Rezoning Transportation Analysis
Petition Number: Insert Zoning Petition #2021-264
General Location Identifier: 04324115

Revision Log:

Date	Description
04-28-22	First Review (PDM)

SHEET DESCRIPTION: CONDITIONAL USE PLAN
 C-1

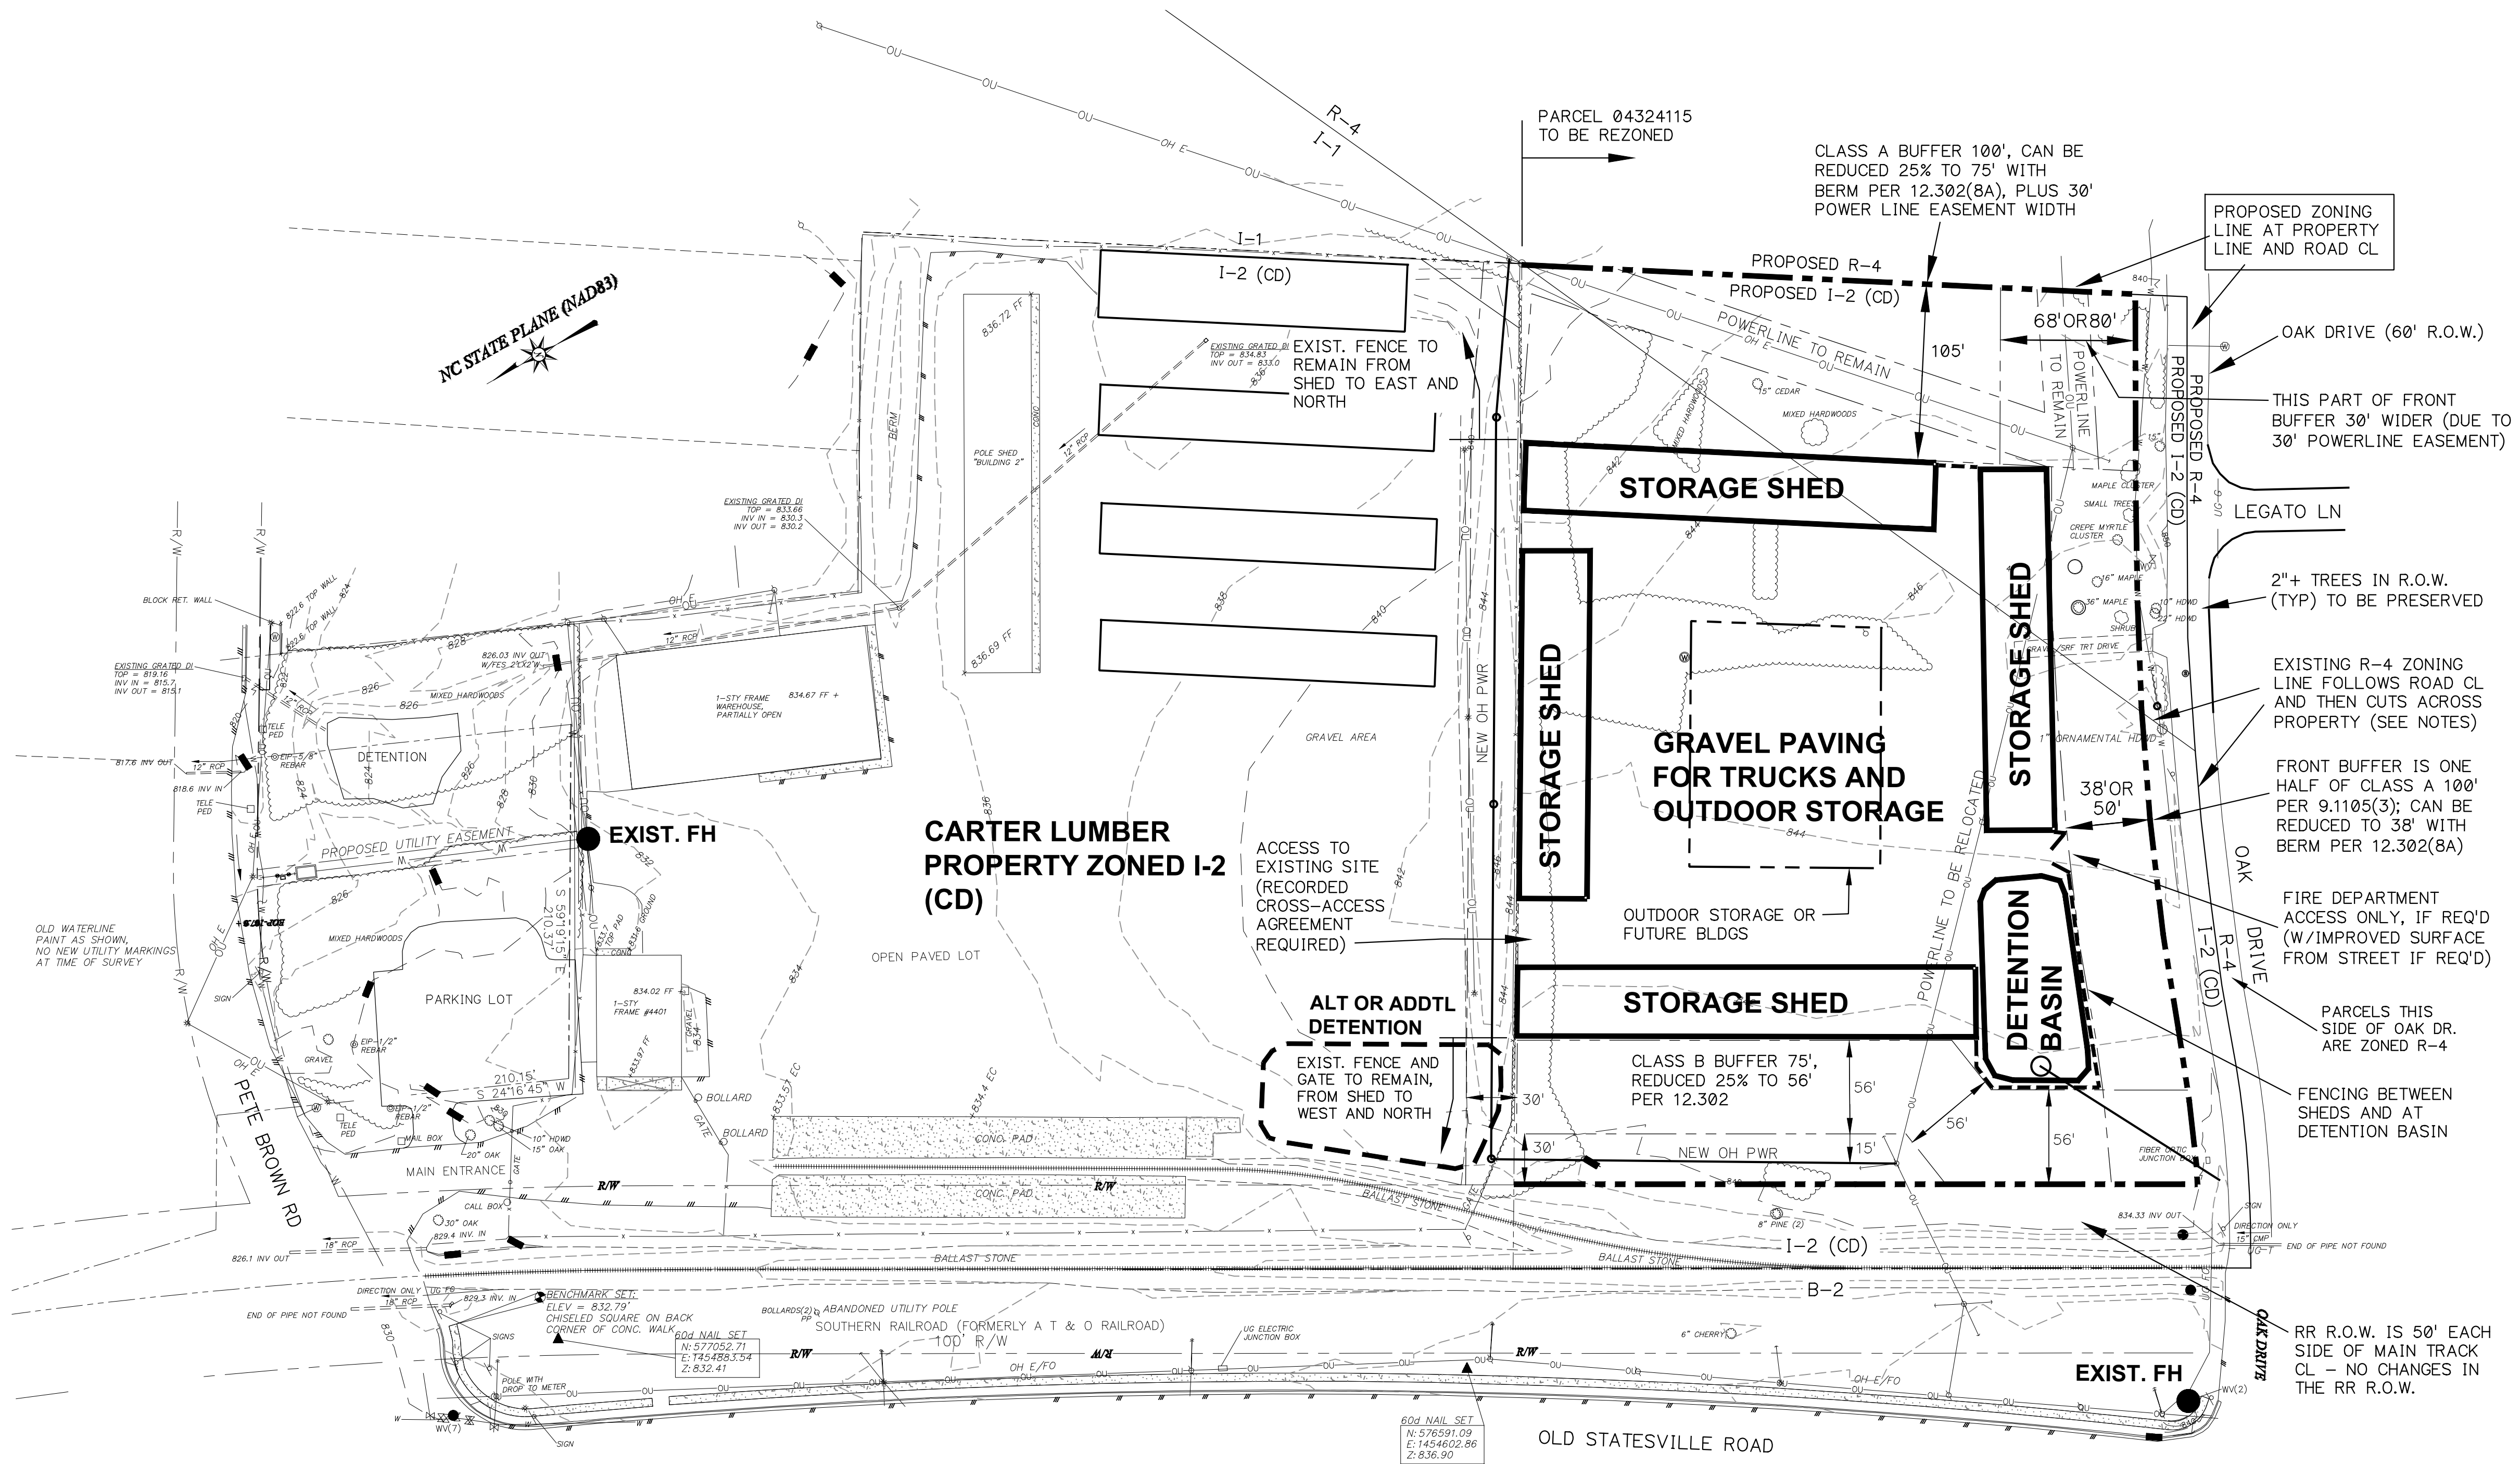
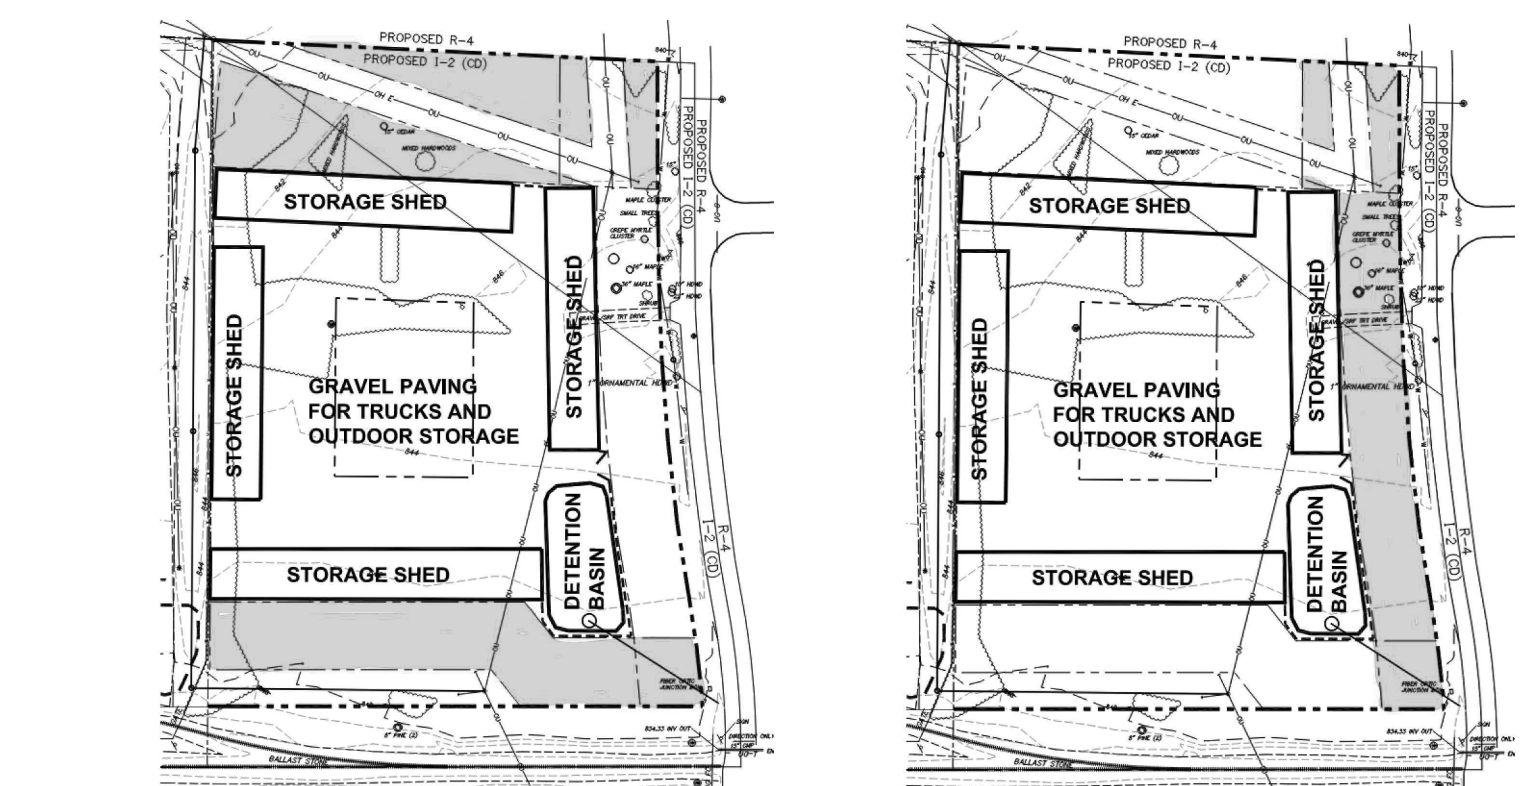
3. CDOT requests that site plan and conditional note(s) revisions are made to commit to constructing curb and gutter along Oak Drive. The location of the future gutter is 15ft from the road centerline per the Local Industrial Street typical section (CLDSM U-06). Per the Chapter 19 Ordinance, curb and gutter is not required based upon the proposed site use.

4. CDOT requests that site plan and conditional note(s) revisions are made to commit to constructing an 8-foot planting strip and 6-ft sidewalk on Oak Drive per the Local Industrial Street typical section (CLDSM U-06). Per the Chapter 19 Ordinance sidewalk is not required based upon the proposed site use, however CDOT is making this request based upon the guidelines of the council adopted Charlotte WALKS policy.

5. Site plan and conditional note(s) revisions are needed to dimension all public Right of Way from the centerline of all public roadways. CDOT requests 33.5-feet of ROW is dedicated from the centerline of Oak Drive to allow for the future installation of sidewalk and curb and gutter.

6. Site plan revisions are needed to show the location of the railroad ROW. The existing callout on the plan does not point to any linework on the site plan.

7. Site plan and conditional note(s) revisions are needed to clarify how the proposed access point on Oak Drive will be restricted to Fire Department access only. In addition, revise site plan to show how the driveway will access the public road.
8. Site plan and conditional note(s) revisions are needed to clarify what is happening to the existing gravel driveway on Oak Drive that accesses the site. If the driveway will be closed as part of the project, add a callout to remove the driveway.
